**Re: Sombra del Oeste Subdivision at 8735 Gibson Blvd. SW
Erosion and Sediment Control Plan
Engineer's Stamp Date 1/13/25 (M09E032)**

Based on the information in your submittal, received on 1/14/25, the ESC Plan cannot be approved until the following comments are addressed.

11/18/2024				DATE
ADDITIONAL DISTURBED AREA ADDED				
1				#

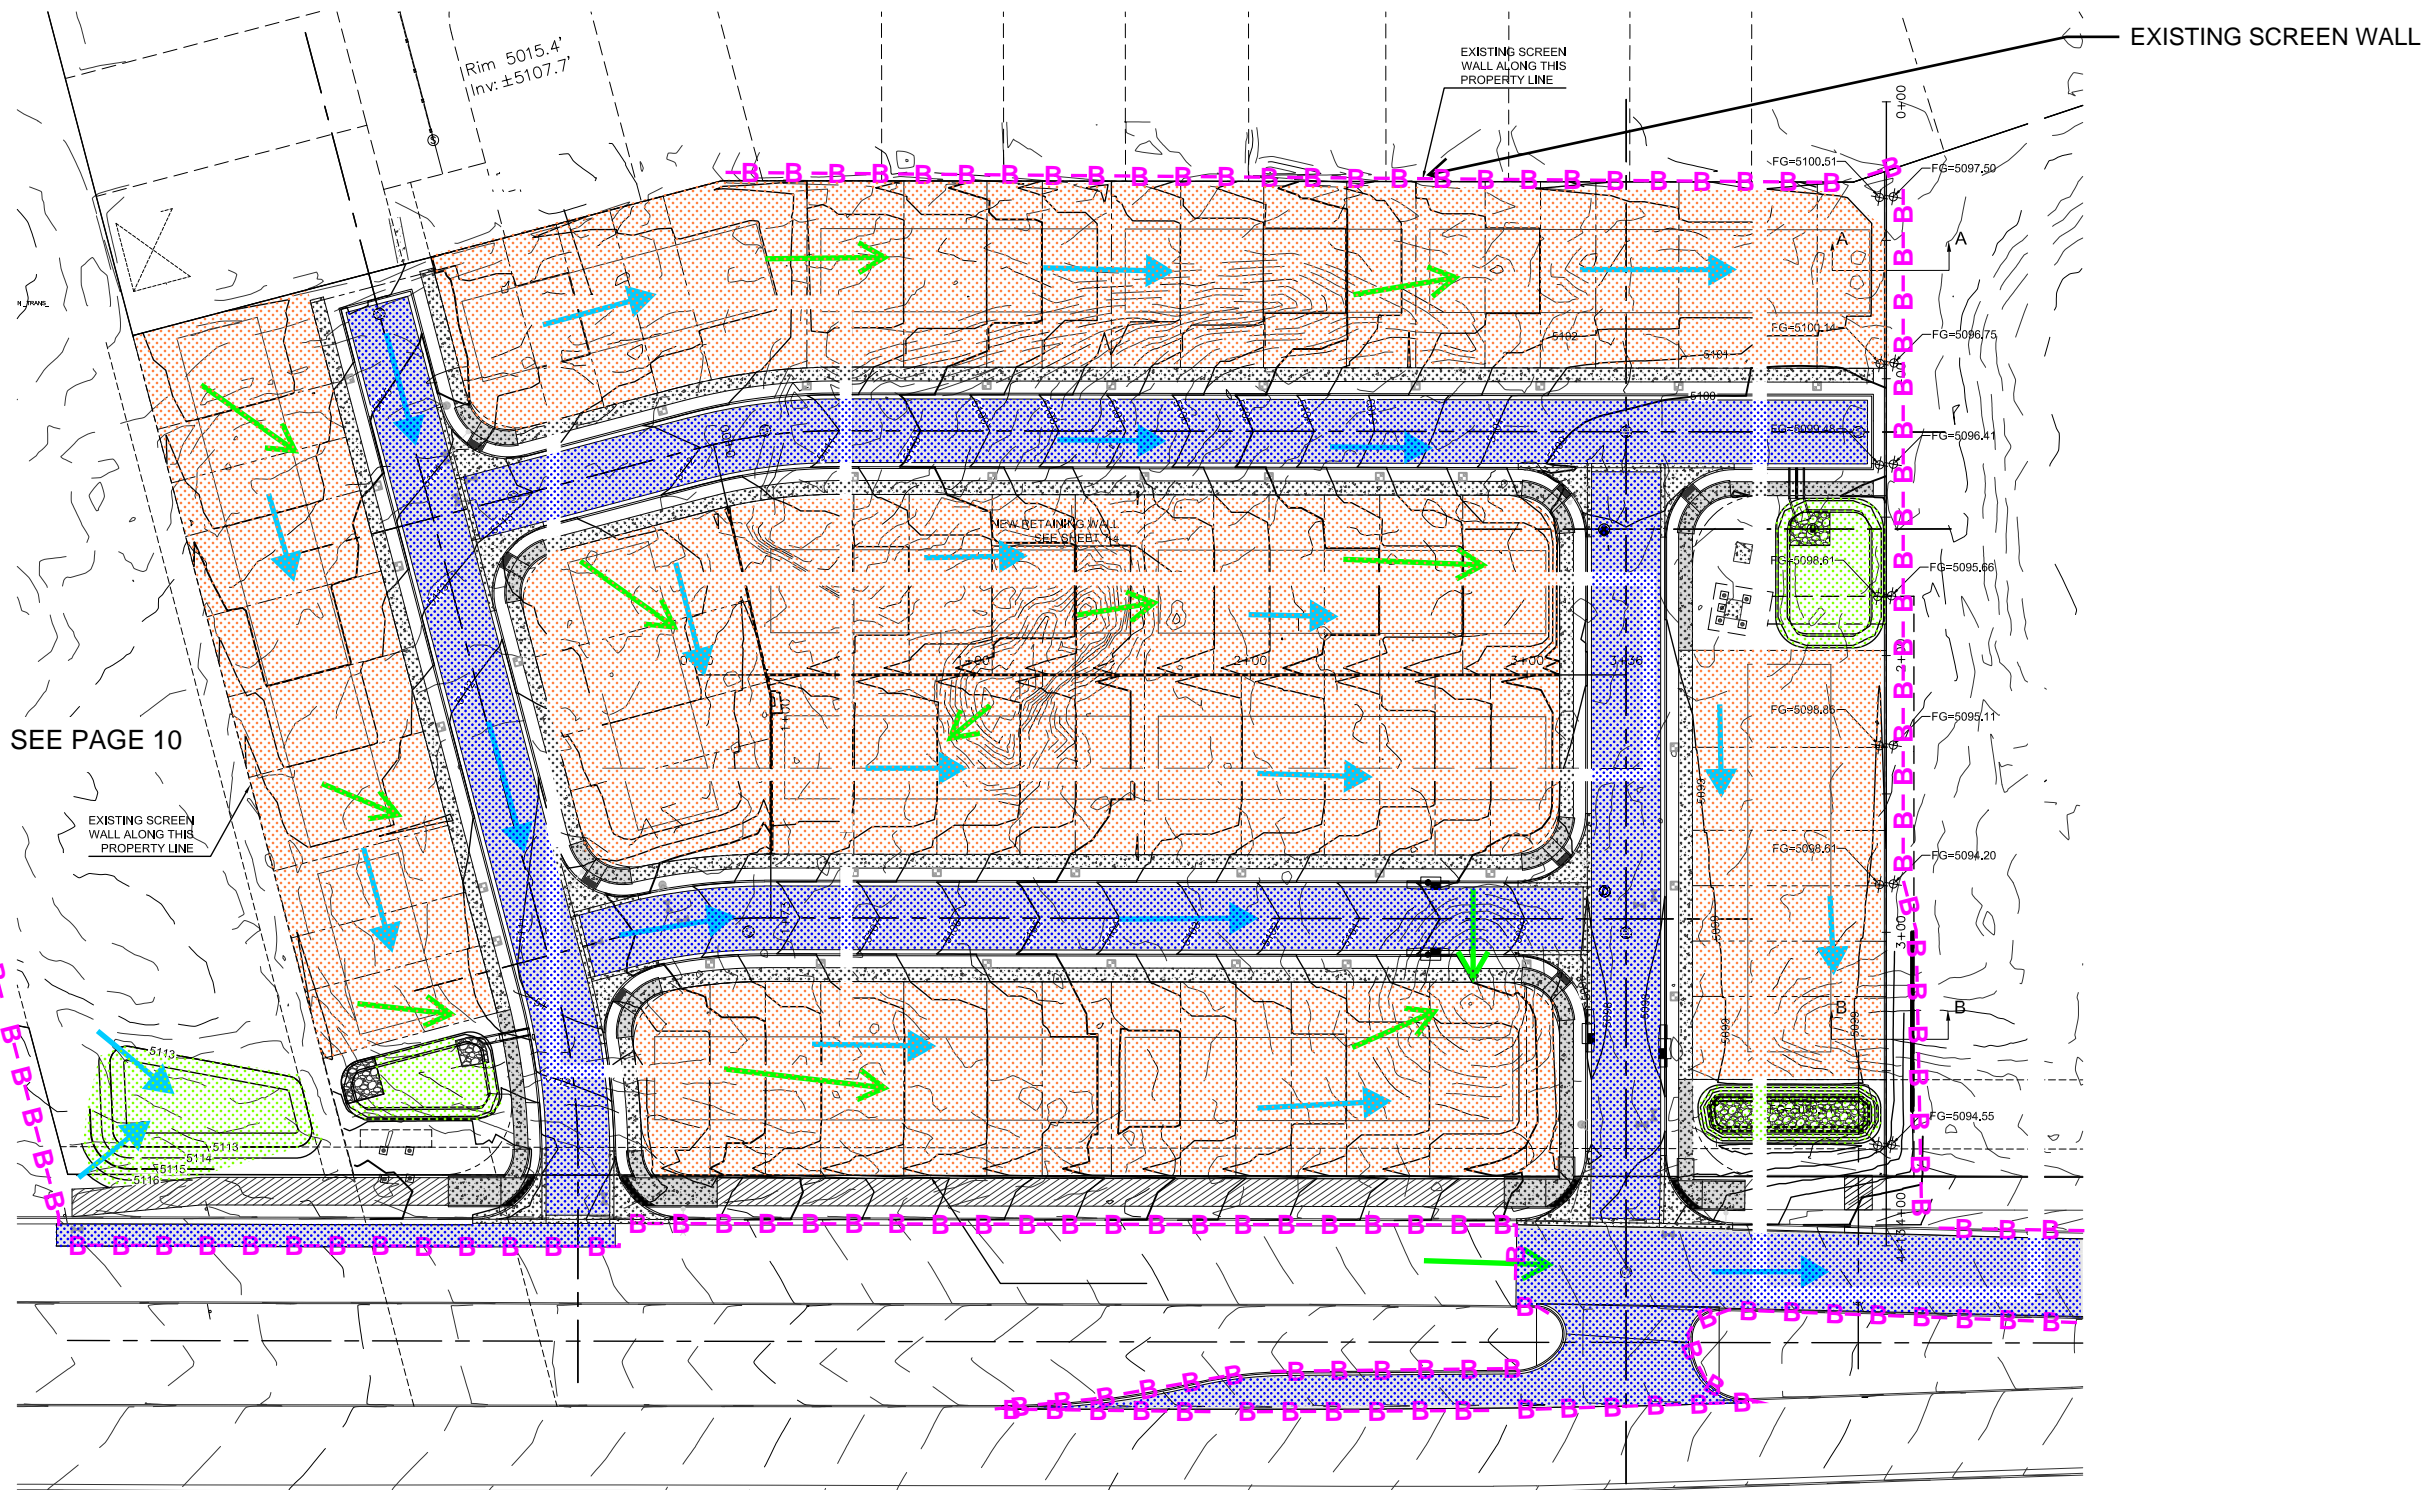
1. Ponds B and C have been redesigned to retain the SWQV on the Work Order Plans and the G&D Plan as required by DPM Article 6-12. They are also identified as the first construction items with notes on the SWPPP Map, sheet 8. However, the "Sequence of Activities" on sheet 2 of the ESC Plan does not include these two ponds as temporary sediment basins. Sheet 2 needs to identify the initial construction and maintenance as temporary sediment basins and the conversion of the ponds to post-construction SWQ ponds at the end of the WO. The Sequence on sheet 2 of the ESC Plans should divide the construction activities and associated BMPs into two phases, describing the transition from the Work Order (WO) to the Building Permit (BP) Phase.

2. The location of the controls during each phase must be shown on the SWPPP Map. The location of ponds and berms is generally specified on sheet 8 of the ESC Plan for Phase 1, but the location of Cutback Curbs and Silt Fences for Phase 2 is missing from the Map. The Cutback Curbs only apply where the sidewalk construction is deferred to Building Permits. The location of sidewalks to be constructed with the Work Order and the deferred sidewalks should be clearly shown on the ESC Plan.

4. The grades and layout of the streets and lots on the ESC Plan must agree with the approved G&D Plan including sheet 11.
5. The street longitudinal slopes must be shown on the ESC Plan (also typically required on the G&D Plan). Silt-fence or check dams must be located between each lot in the Cutback Curb Swale where street slopes exceed 2%.

6. Consider removing or closing the southeast construction exit during rain since it is on the low side of the development and is highly likely to be muddy.
7. Update the engineer's stamp date on all sheets when a change is made to any sheet.
